Planning Consultation on: WA/30/20/PL

Walberton Parish Council **object** to this planning application on the following basis:

Drawing.
Proposed Site Plan

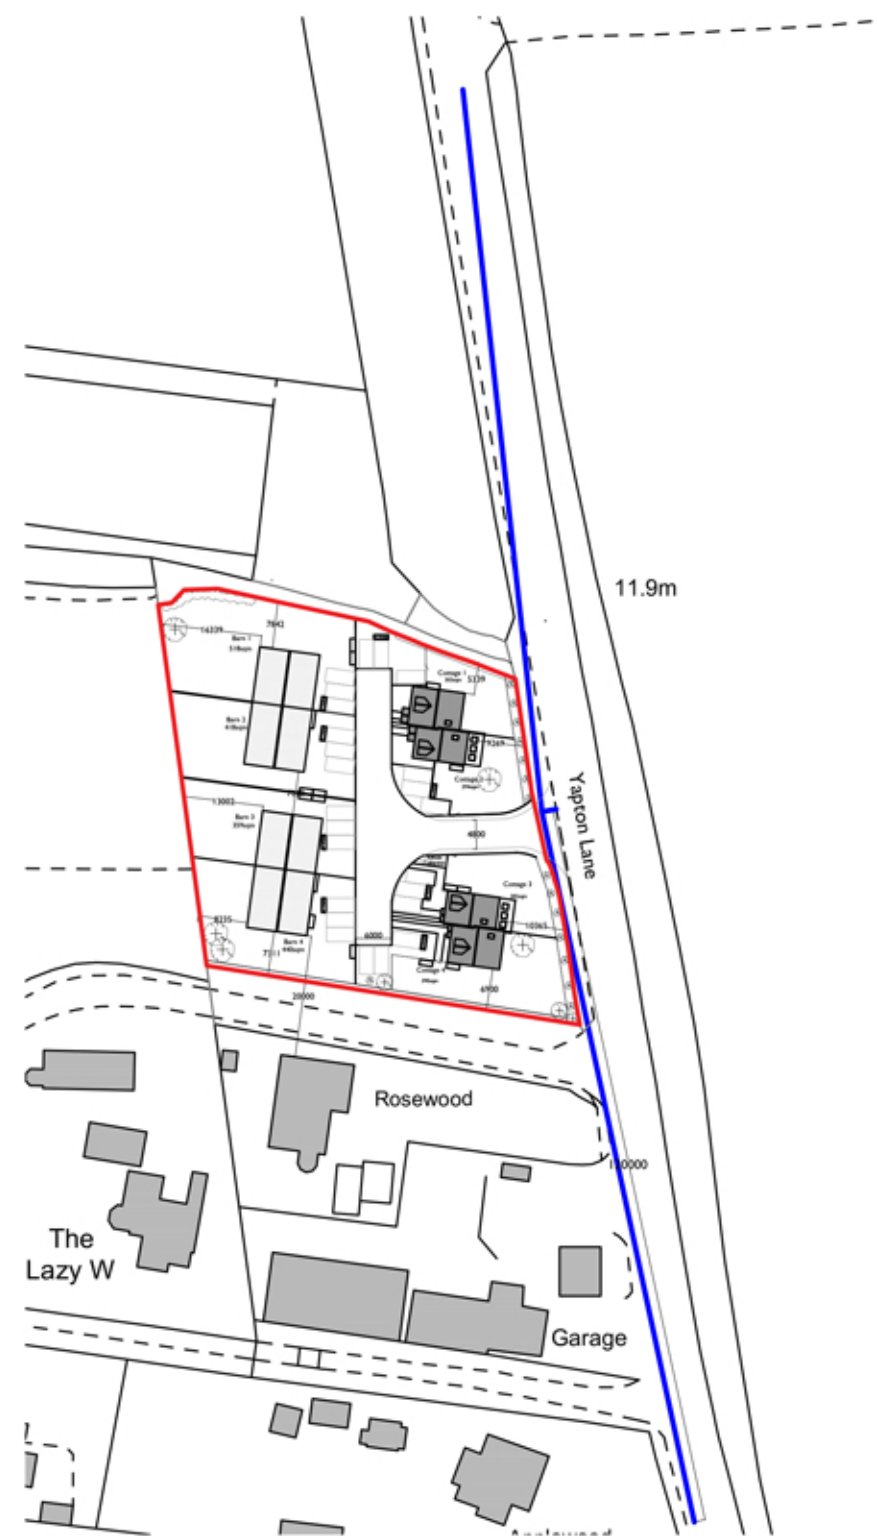
1. The site was not selected for the revised NDP currently at draft Reg 14 stage.
2. It was not recommended by AECOM our independent site assessors that advise the NDP team.
3. The site is not suitable for allocation in the neighbourhood plan as it does not meet Policy C SP1 or Policy SD SP2 due to its location outside the BUAB.
4. A lack of safe pedestrian access would also be a constraint to development.
5. The density is inappropriate to the locale at eight dwellings and 2.5 storeys is also out of keeping with the area.

The site lies outside the built-up area boundary as defined in the Arun Local Plan 2011 - 2031 and Walberton Neighbourhood Development Plan and would represent an encroachment of built form into the countryside. By reason of the number of dwellings proposed and their siting the proposal would be at odds with the character and appearance of the locality. The proposal would therefore be contrary to policies C SP1, D SP1 and D DM1 of the Arun Local Plan 2011 - 2031 and policies HP1, HP11 and H13 of the Walberton Neighbourhood Development Plan.

P2.5 is misleading claiming good pedestrian access. The site opens out onto the busy Yapton Lane which has no pavement until the start of the village some 900 metres away.

P 8 – 5.1 - 1) 2nd sentence references the fact that the previous application for 5 two storey houses was refused noting that it was at odds with the character and appearance of the locality. Therefore, how can 8 dwellings, of which 4 are 2.5 storey now be in character?

P 23 – 7.25 references WA/29/17/RES in which a brownfield site (note that this application site is not brownfield) with 2 storeys houses was considered to be acceptable. Para. 7.26 then implies that this application with 2 storeys should be acceptable, but this application has

4 houses on the frontage that are 2.5 storeys, which we deem inappropriate and unacceptable.
